Subject: RE: Y/9818/RES and Y/97/18/DOC

Laura Gibbons, MEng, GMICE
Engineer (Drainage & Coastal)

Job Title			
LAND SOUTH OF BURNDELL ROAD, YAPTON			
Drawing Title			
PRELIMINARY ENGINEERING LAYOUT			
Client			
BOVIS HOMES			
Scale	Date	Designed	SG
1:500 @A1	NOV 18		
Drawn	Checked	Approved	RS
SOM	LH		
Job No	Drawing No	Rev	
18-070	18-070/103	K

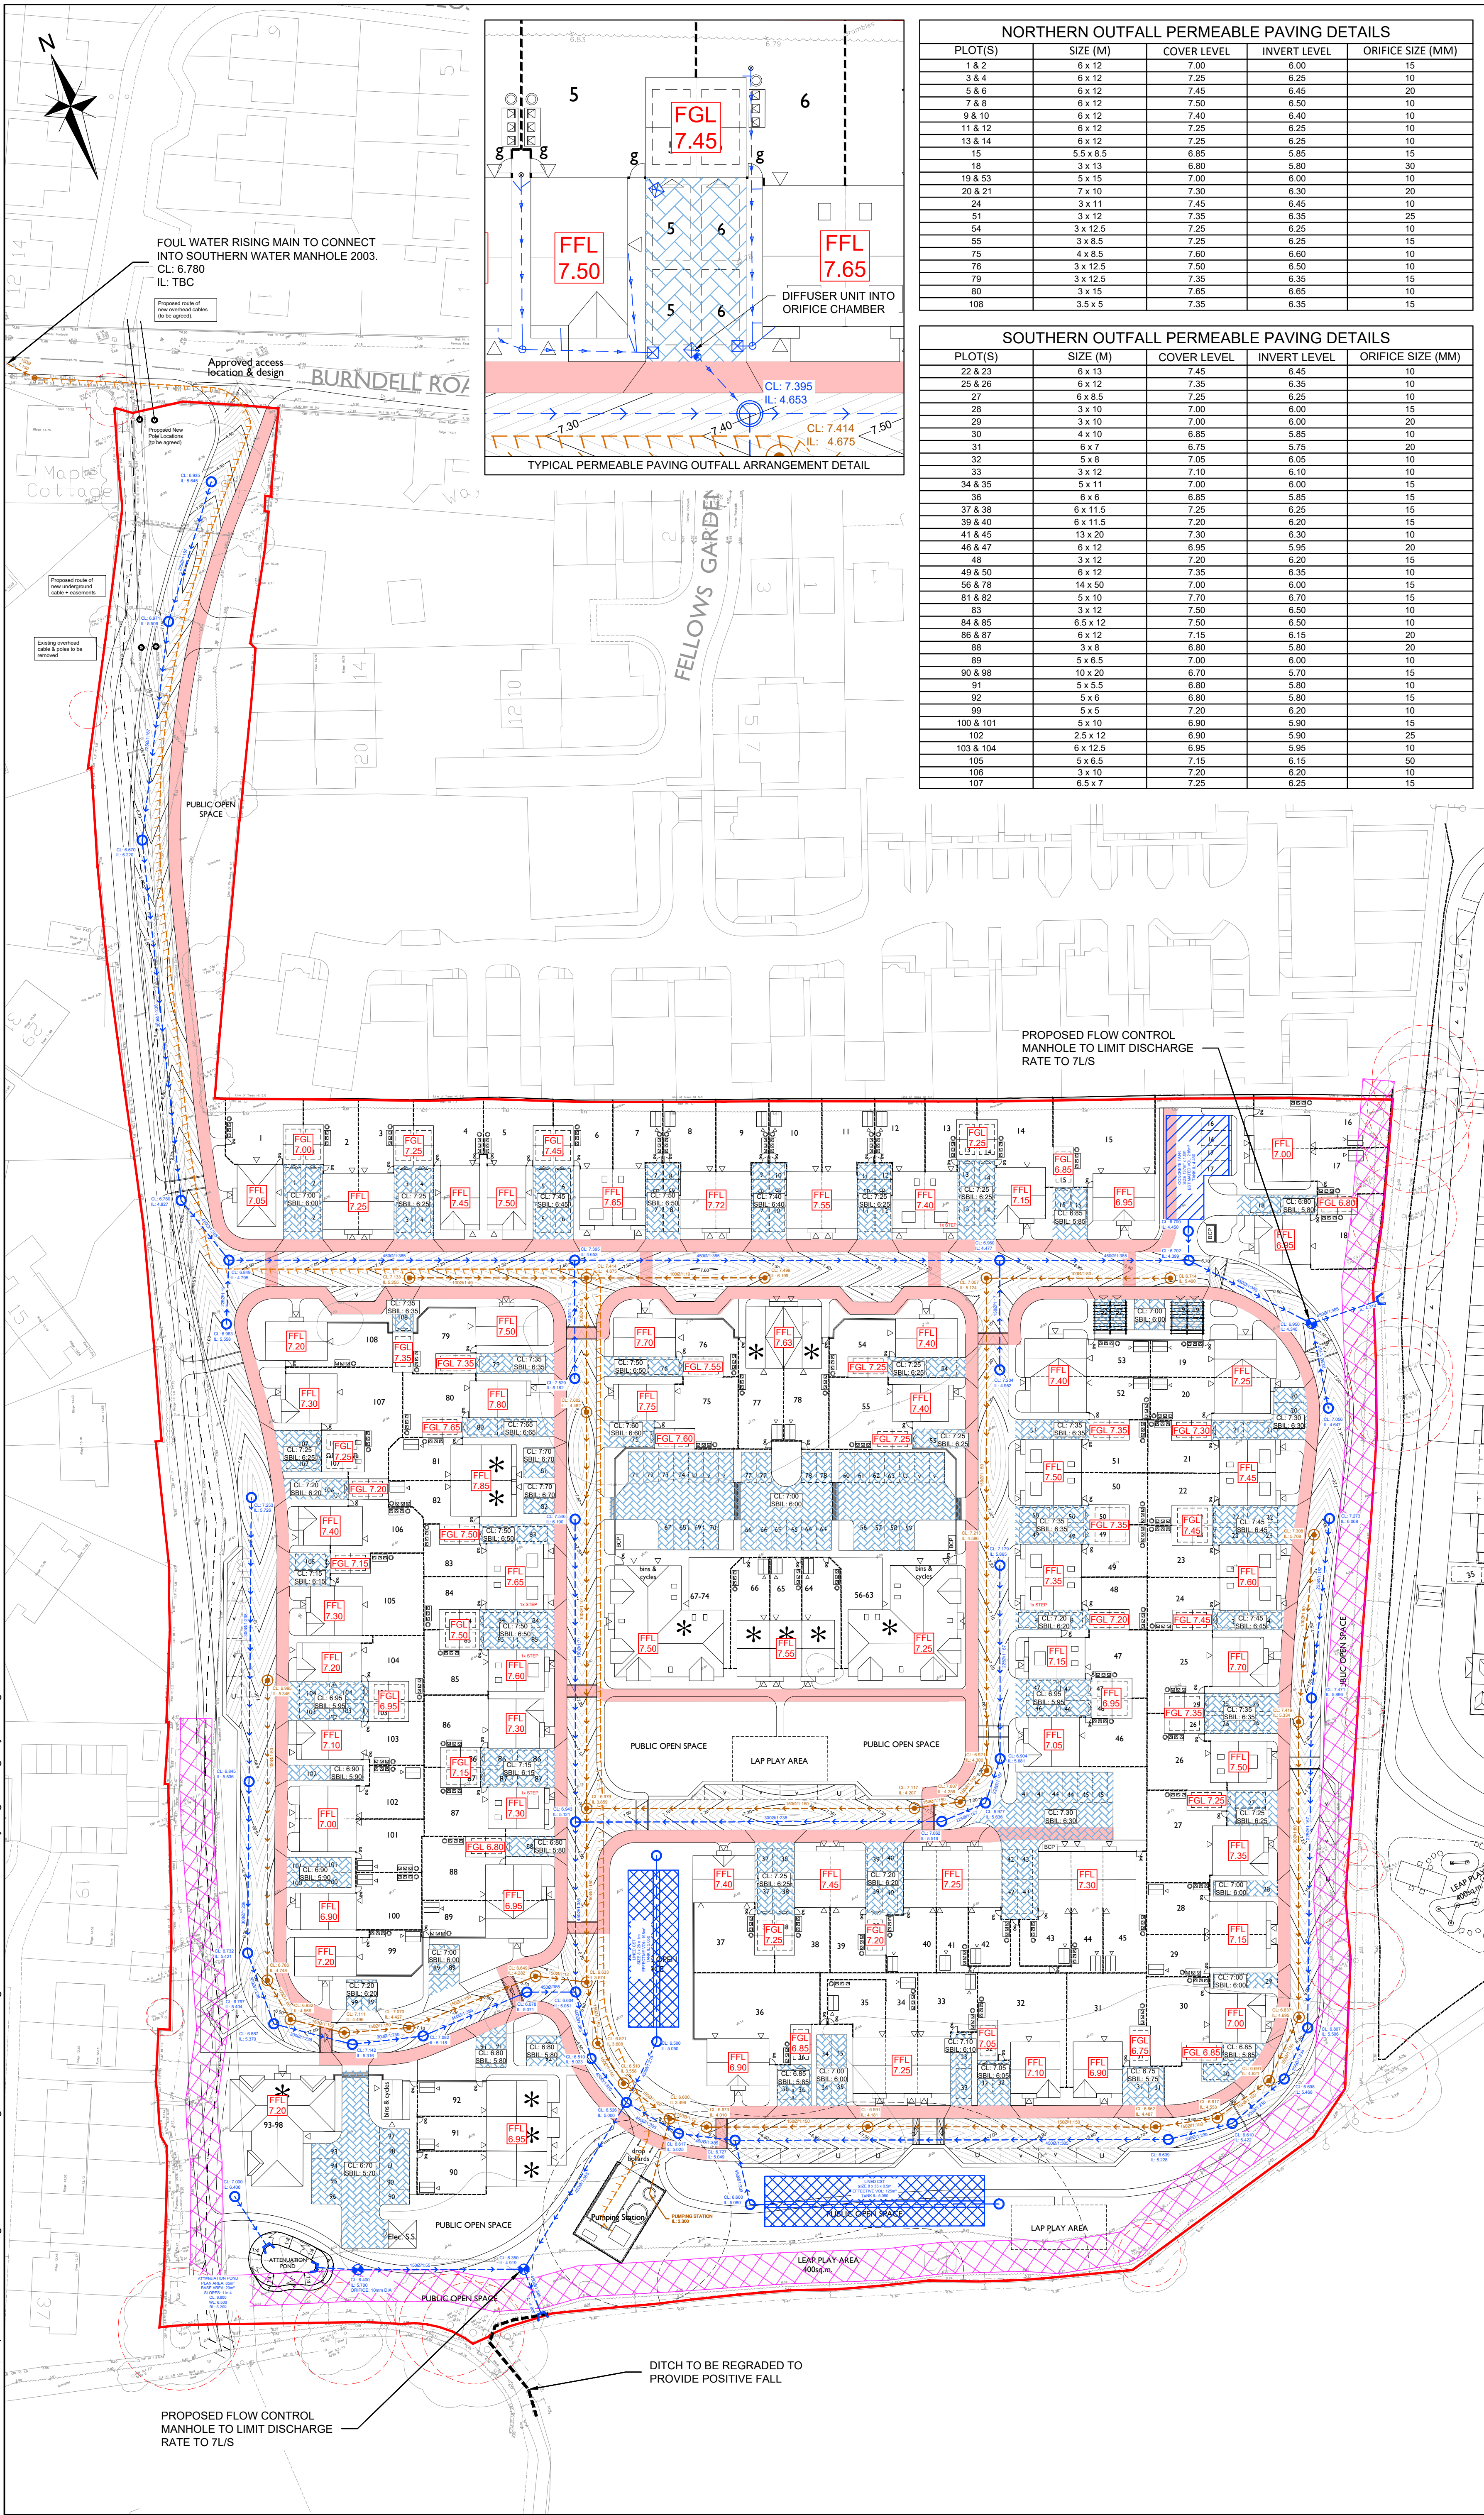
12. *Can you look at providing some upstream connections to the two southern tanks, to make them more online rather than offline. Offline tanks should be avoided where possible. I acknowledge that the northern most tank may have to stay offline.*
